**S73 VARIATION OF CONDITION APPLICATION TO VARY CONDITION 2  
(APPROVED PLANS) OF PLANNING APPLICATION 19/01856/FUL**

**Proposed farm diversification to create a children's adventure play within Alresford Hall Farm**

**Alresford Hall, Ford Lane, Alresford, Colchester**

Drawing Number
GA_02

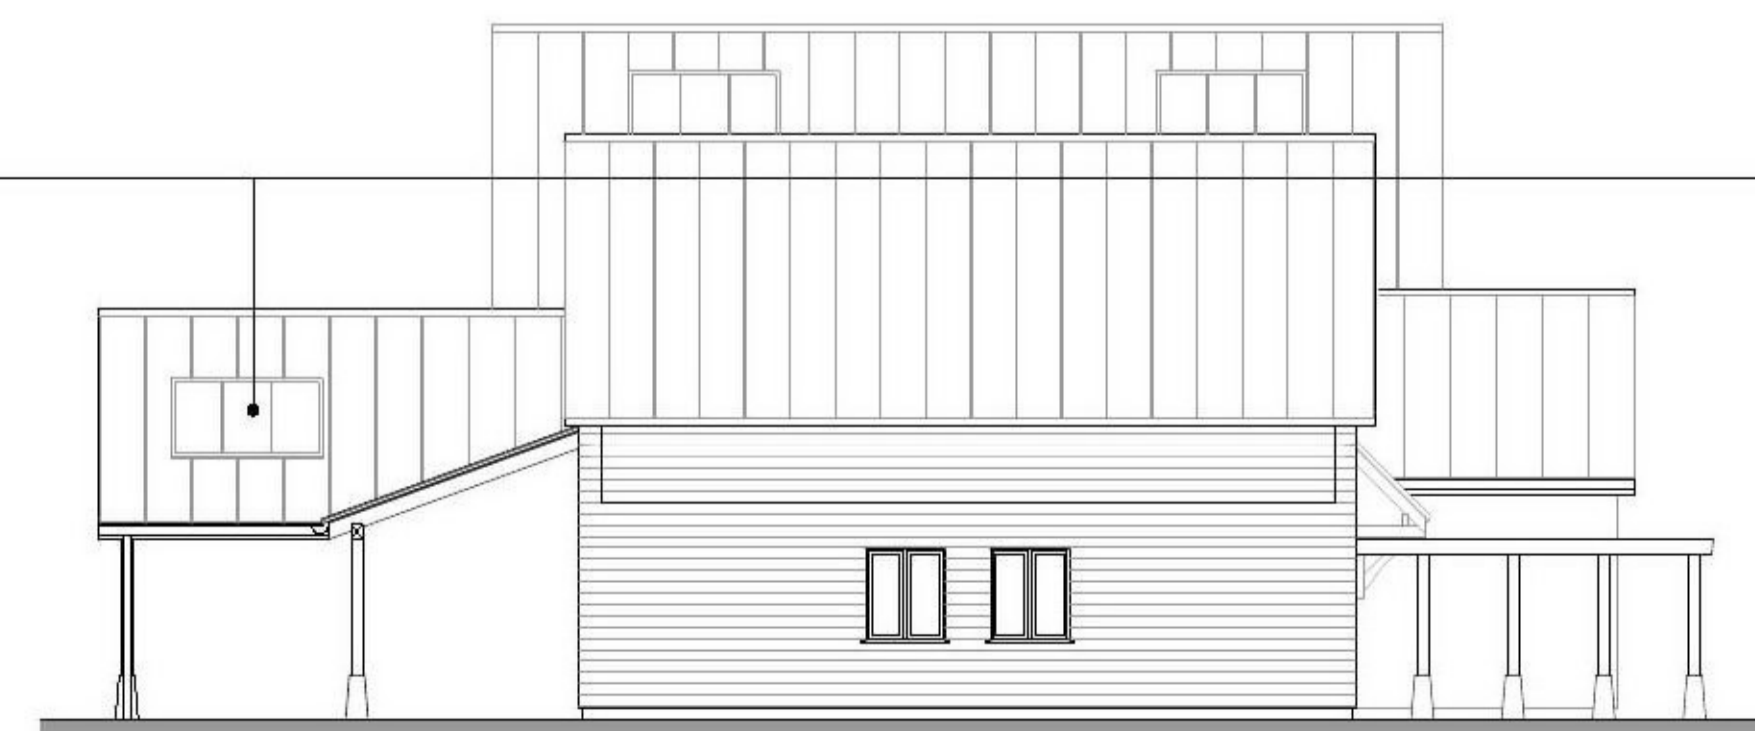
The building has amendments to the elevation to replace the part of the front elevation where the Galleon was connected to the building. The proposed elevation continues the design aesthetic of the approved plans, with a blank timber-clad gable wall. Again, revised elevations and floor plans are submitted within this application.

<b>ROUND WOOD DESIGN</b>	PROJECT WYVERNWOOD	<b>DRAWING TITLE</b>	Galleon material details- Perspective	<b>DRAWN BY</b>	ST/TR	<b>DATE</b>	10.06.2021	All dimensions in metres unless otherwise stated. Scale at A3	<b>A 02</b>
		<b>DRAWING NO.</b>	WYV-01-02-02	<b>REVISION</b>	02

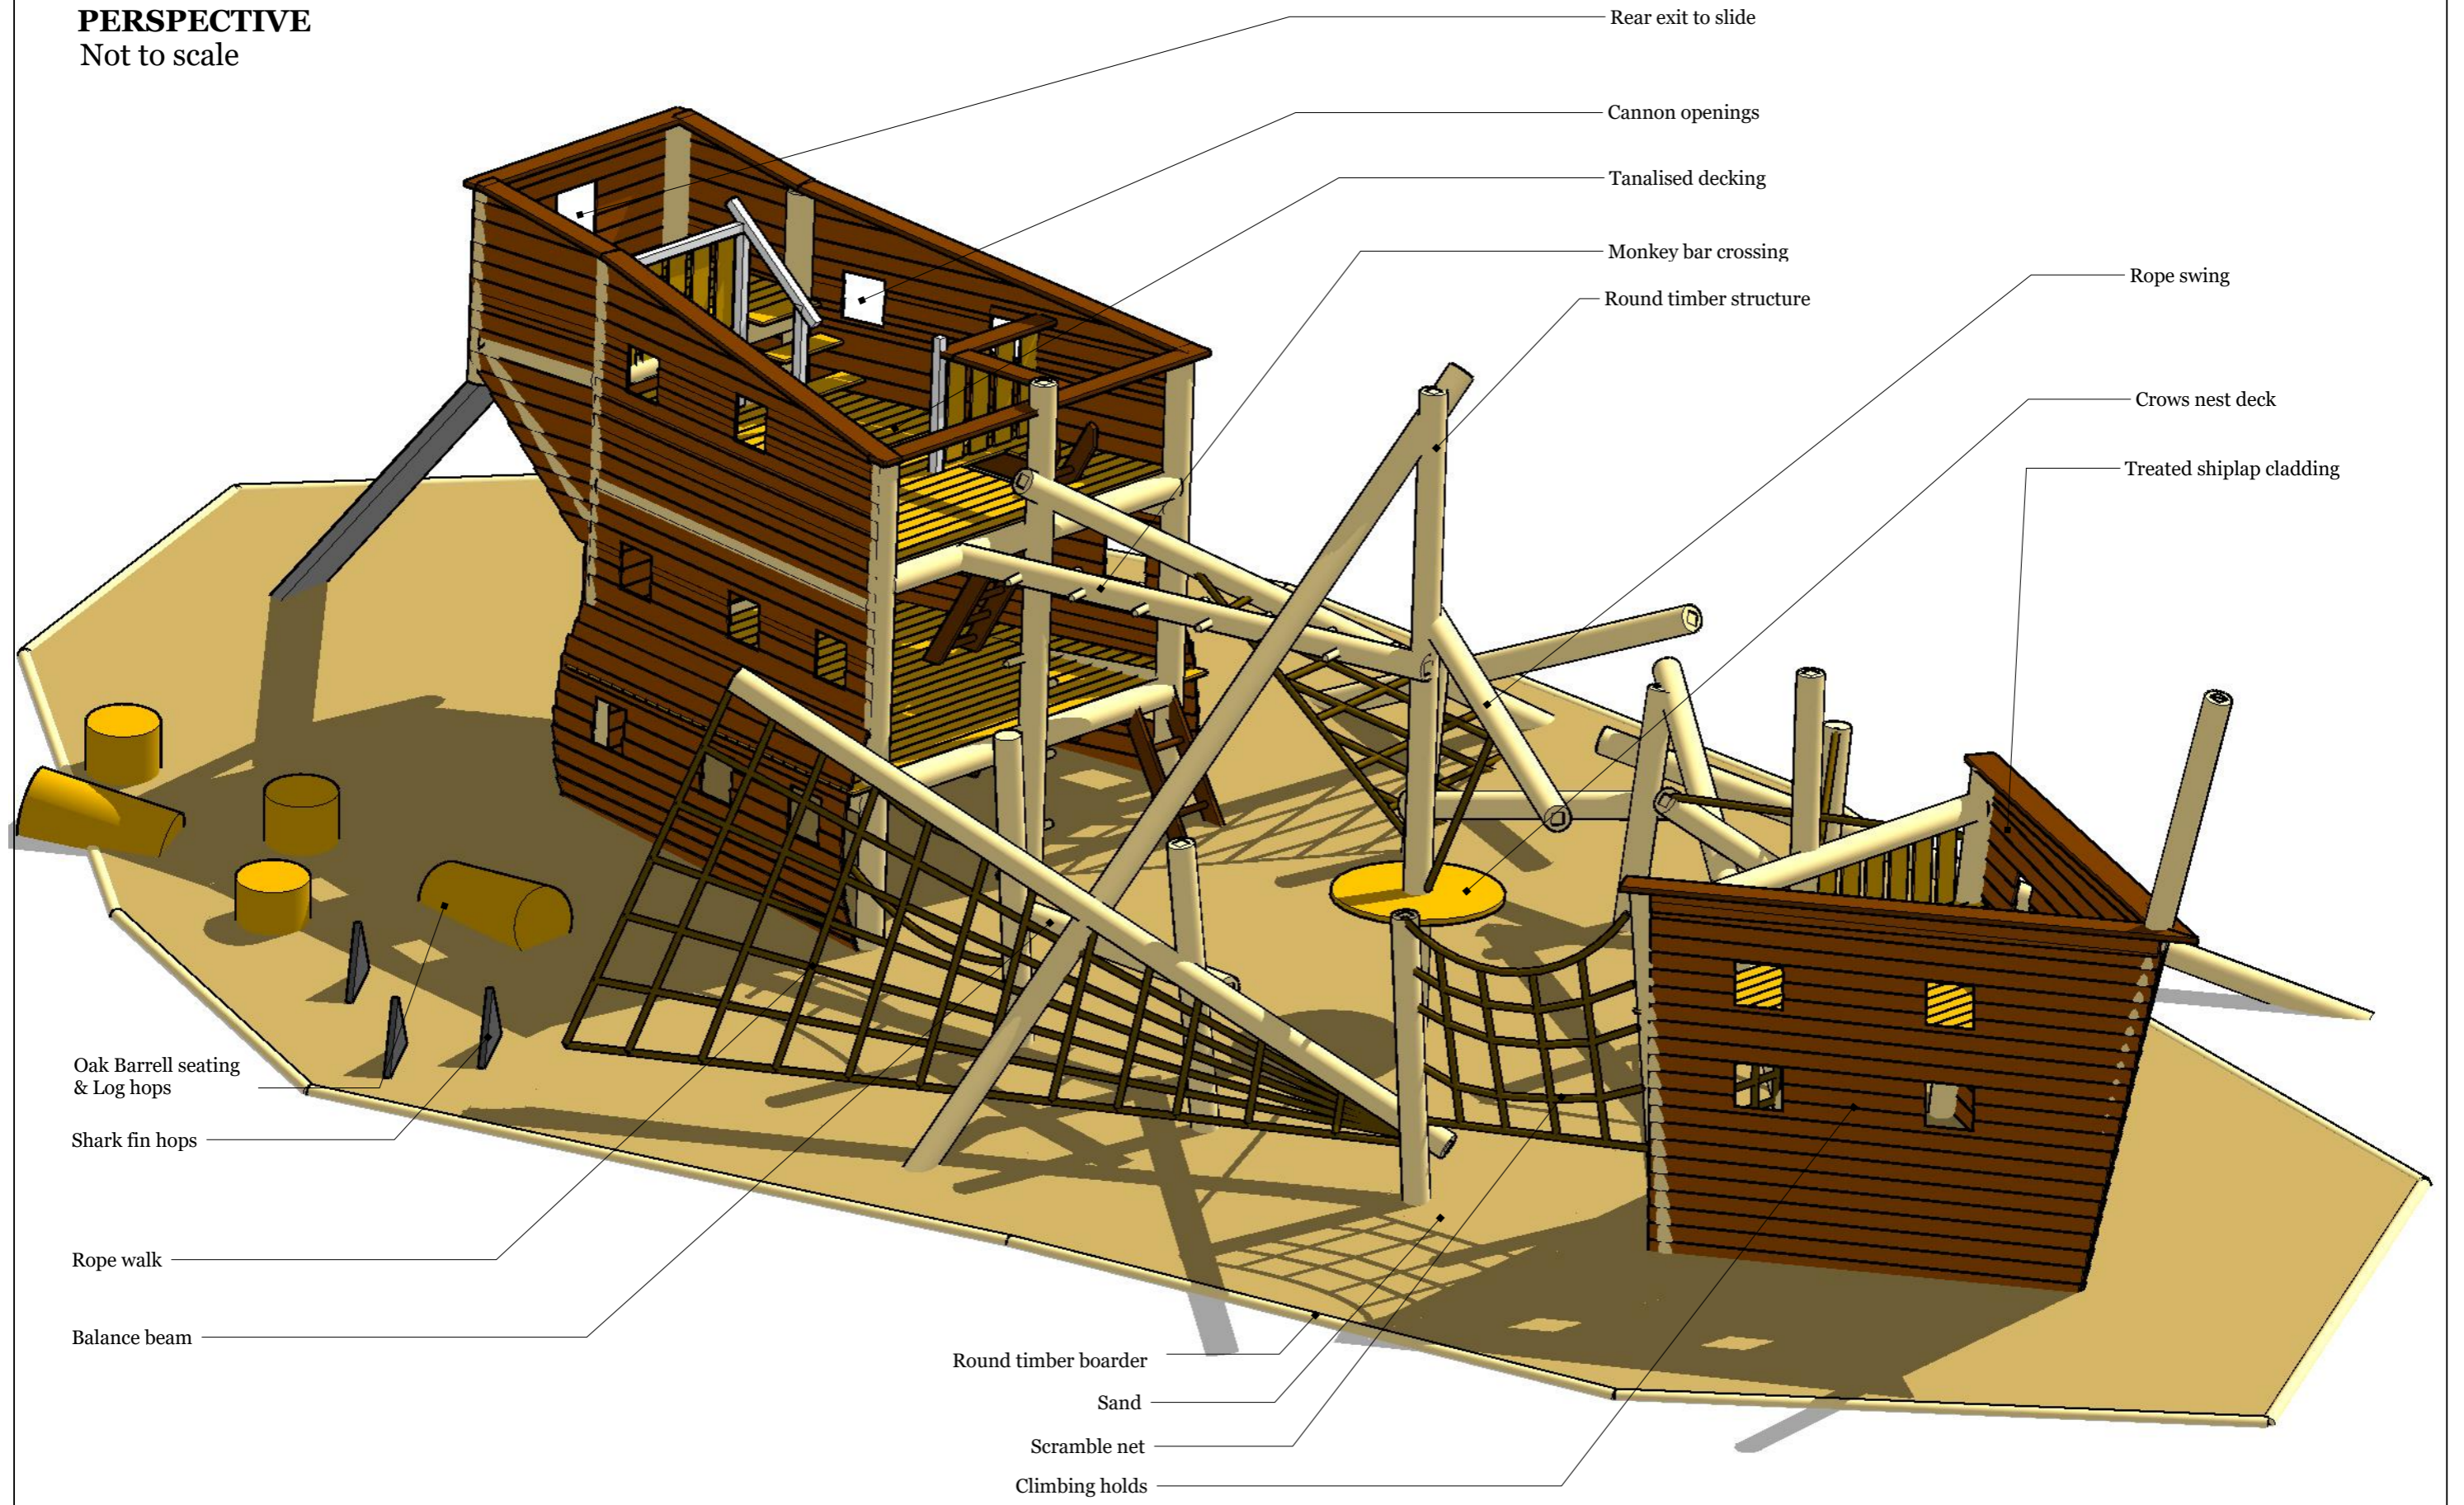
The design of the Galleon is materially as per the approved scheme, including in key (height, length) dimensions. Full plans are submitted for approval within this application.

DRAWING NO. WYV-01-03-02

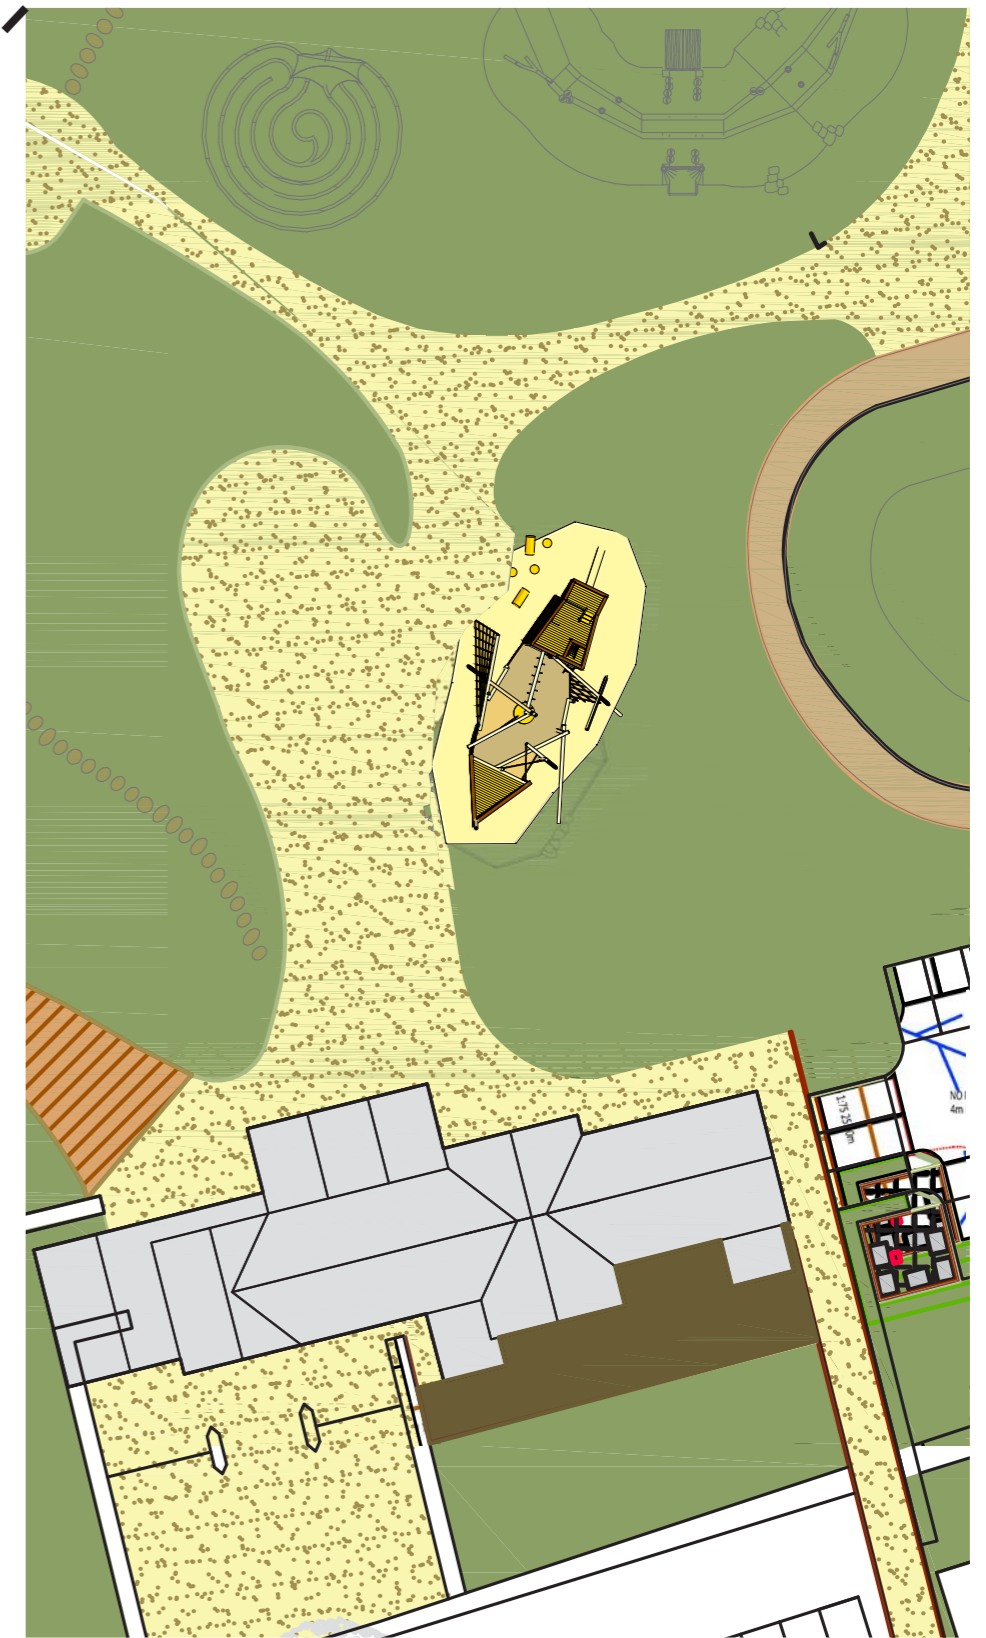
As such it is proposed to remove the galleon ship feature from the building and relocate this to the approved outdoor play areas as a standalone play structure. The proposed siting of the Galleon is shown in new plan WYV-01-03-02.

The proposed siting of the Galleon will be in the approved position for the Sand Play area. The Sand Play area will be relocated northwards to an area to the west of the Water Play adjacent the toilet and shower block.
